From: Kantziari, Stamatia [REDACTED]
Sent: 13 February 2019 14:32
To: Laura Gibbons
Cc: Mulligan, Niall; Prayag, Roddy; Jonathan Pritchard
Subject: RE: Chichester University App BR/311/18/PL

Point 1: The discharge rate from the development has been reduced to 2 l/s. Please find attached the updated drawing showing the Hydrobrake chamber with the limit out flow to 2 l/s based on 0.9m head. We also attach the Micro-drainage results to demonstrate that the model operates satisfactory.

- SITE BOUNDARY
- EXISTING POTABLE WATER PIPE WITH EASEMENT
- EXISTING FOUL WATER PIPE WITH EASEMENT
- EXISTING CULVERTED WATERCOURSE

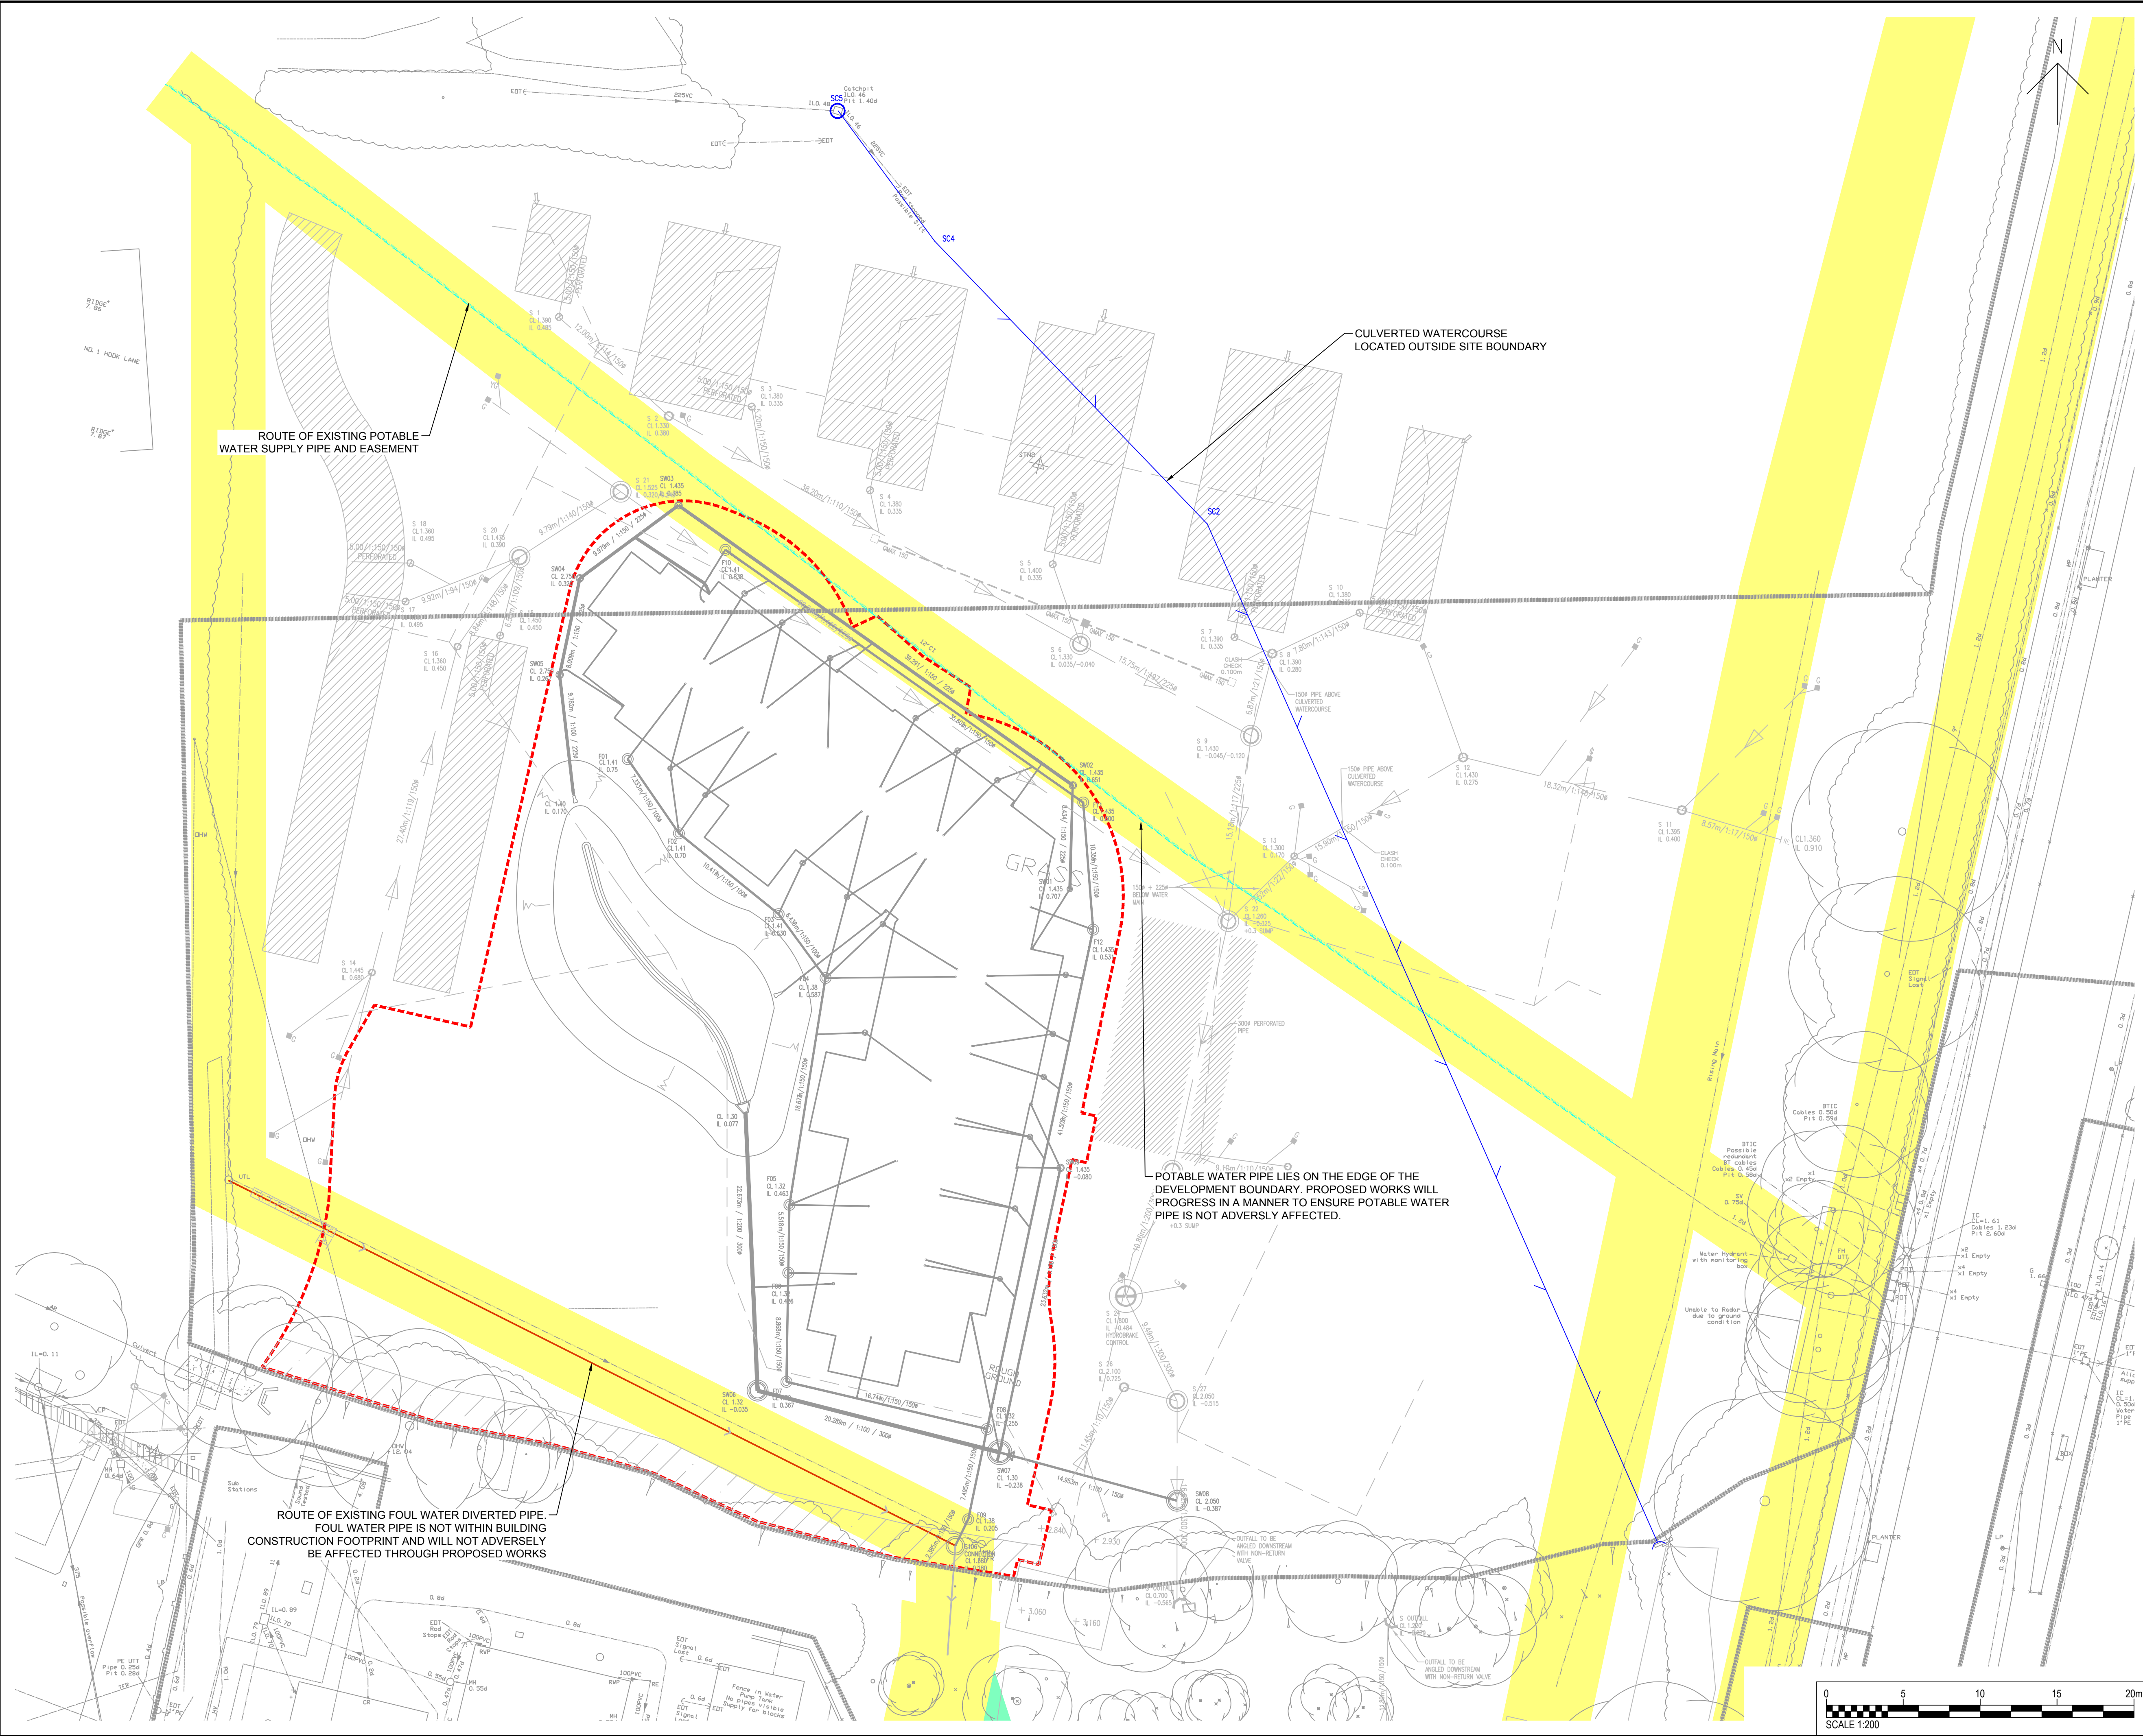
3. Amendments to the surface water drainage strategy or a technical note will be provided to detail points 1 and 2 above.
4. I have attached three plans showing the private sewer, potable water supply and culvert. After discussions with my colleague I understand that the private sewer was previously investigated, I would encourage that you speak to your client and try to get hold of the CCTV report and location drawings. We do have this information on our system, therefore if express permission is provided by the client we can share this with you. Following receipt of information/ investigations please provide a plan showing the location of all of these features relative to the proposed development.

Point 4: Drawing UOCC-ACM-ZZ-05-DR-DR-30003 shows the information we found for the existing potable water pipe with easement, the existing foul water pipe with easement and the existing culverted watercourse. The location of the culverted watercourse is outside the development boundary. The potable water pipe and the existing foul water diverted pipe are within the site boundary but not under the building footprint. Therefore, the works will not be affected.
